Your Ref: TR010064
Our Ref: JXG.HIL206.1
Doc No: 46714424v1
Date: 10 December 2024

Application by National Highways for an Order granting Development Consent for the M60/M62/M66 Simister Island Interchange Project

Written Submission on behalf of the Hillary Family Following CAH1 & ISH2 on 26 - 28 November 2024

FIGURE 2.3

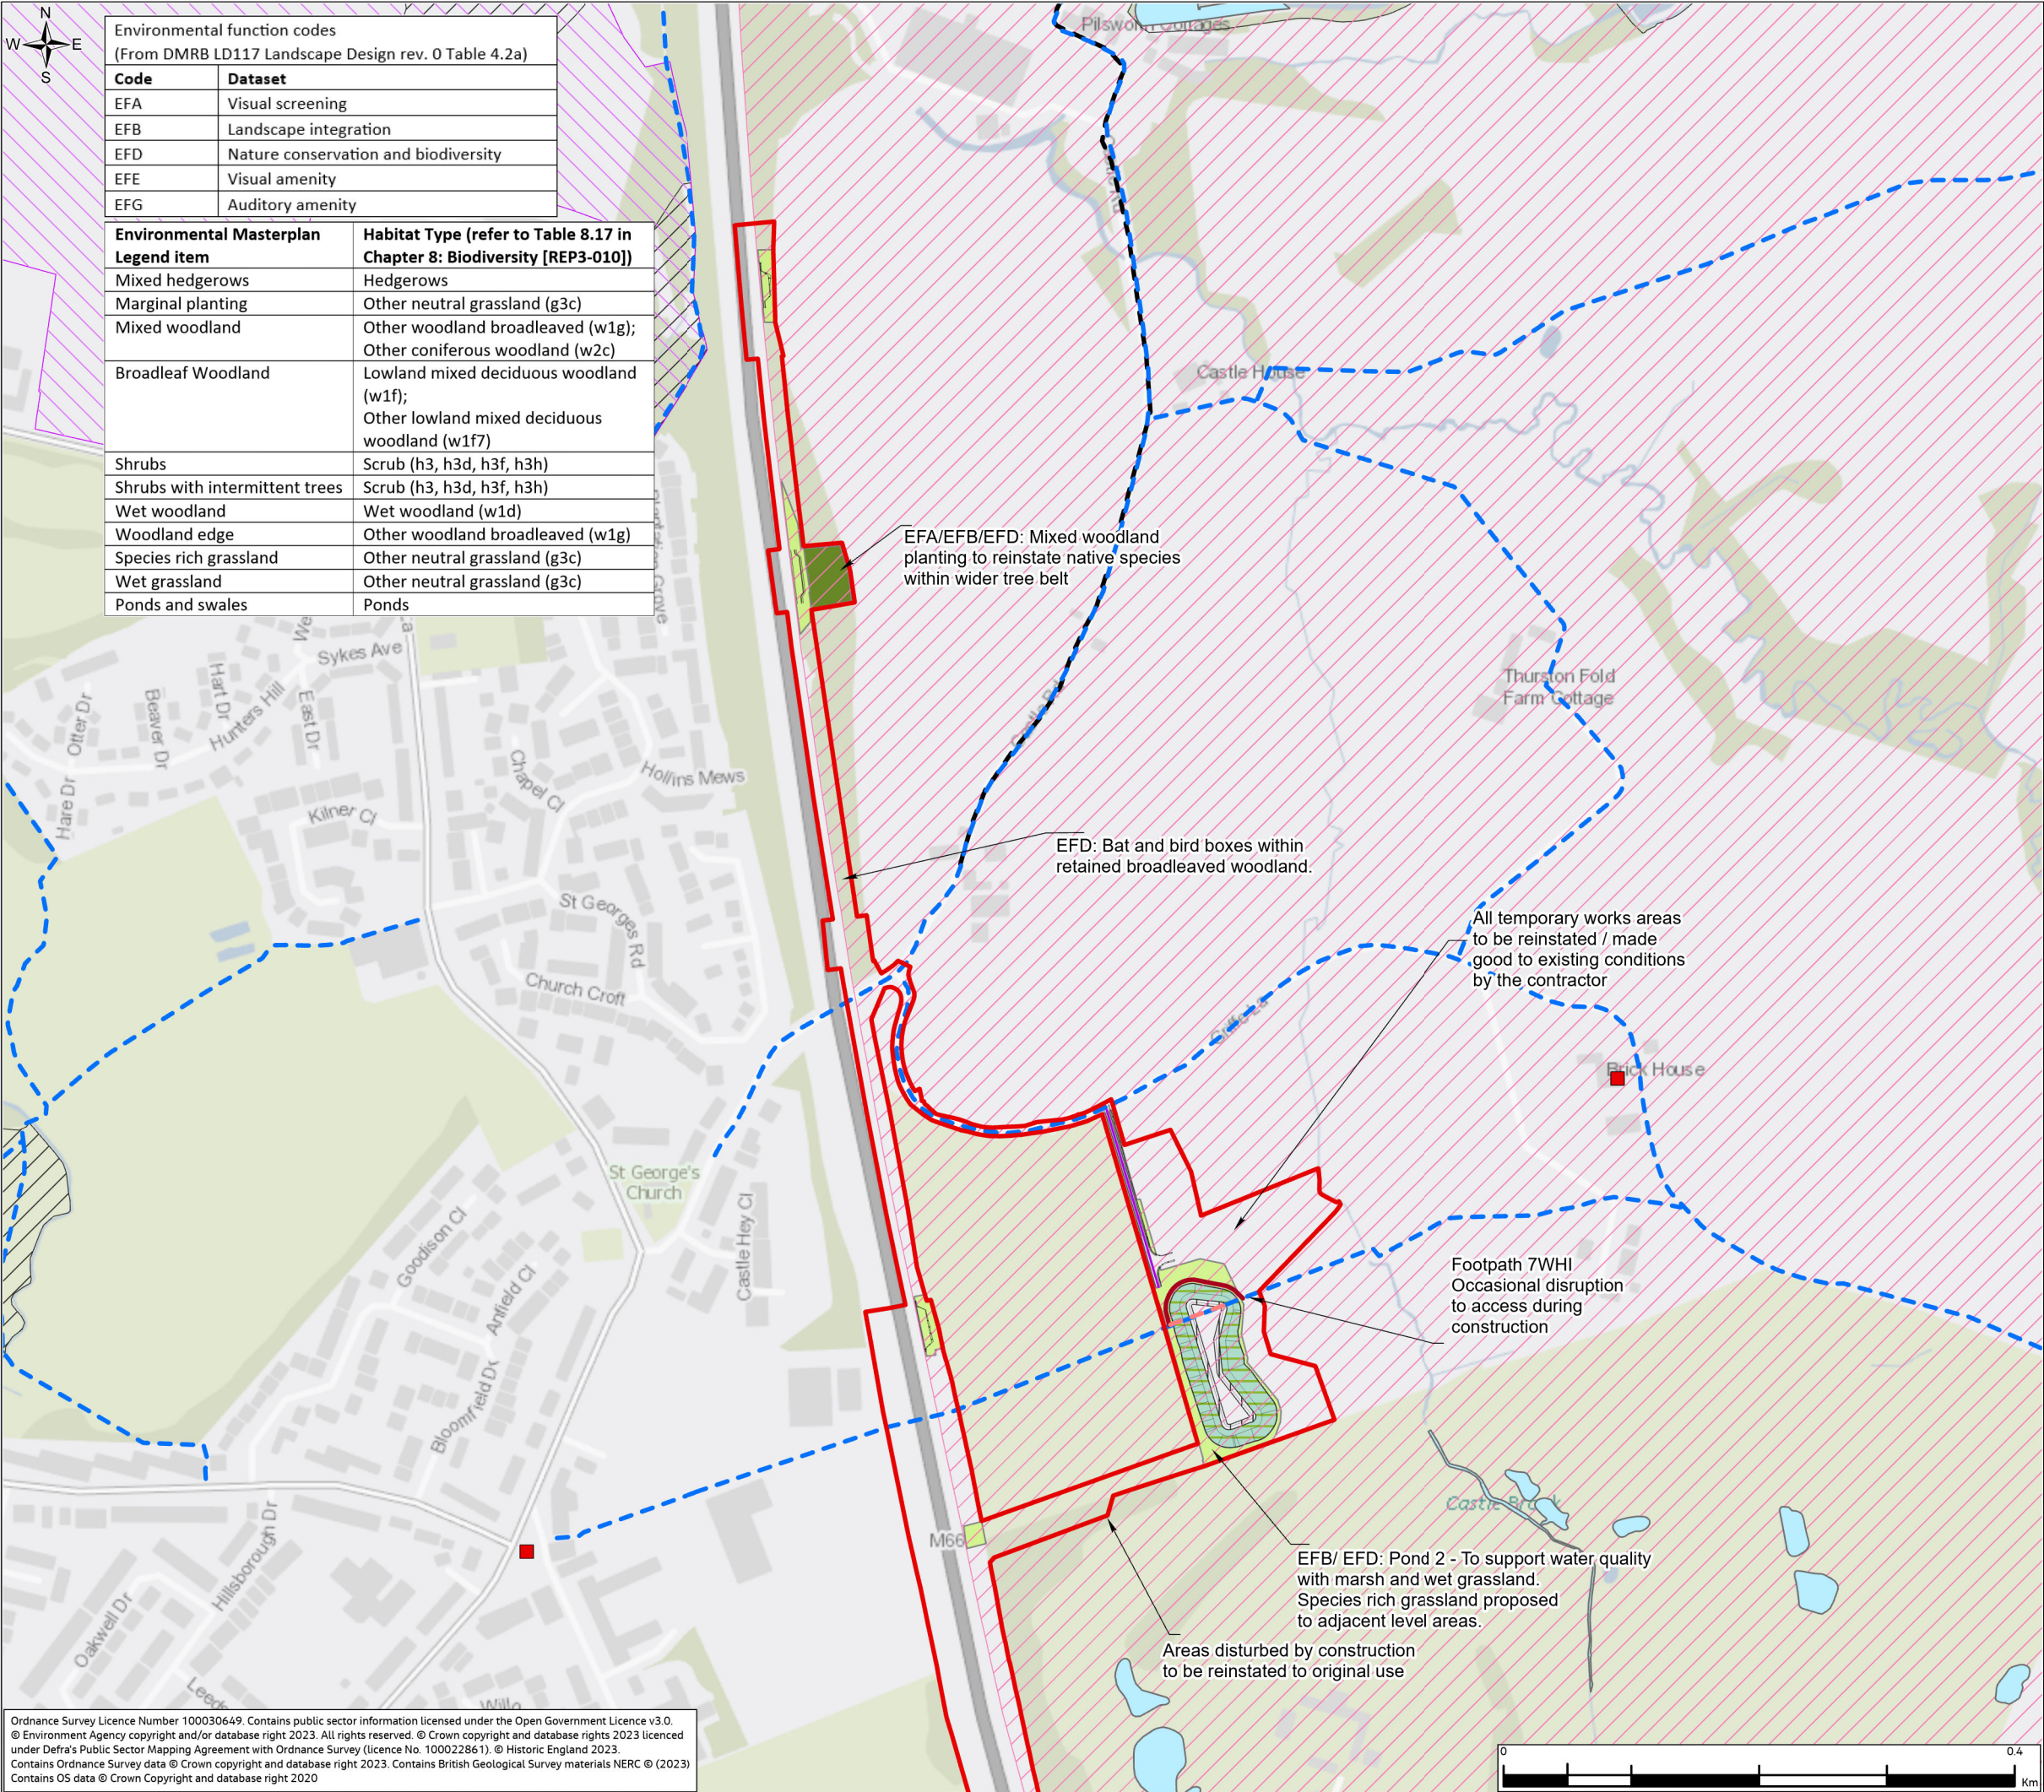
- 1.9. Furthermore, the Applicant's environmental mitigation proposals for the EMAs do not in themselves require any land take within the EMAs, as mitigation proposals can be provided elsewhere. Figure 2.3 of the ES (Environmental Masterplan Sheet 2 of 5, APP-057) reveal indicative locations of tree planting, wet woodland, and log and brush piles. We submit that they do not require the Applicant to permanently acquire the entirety of both EMAs.
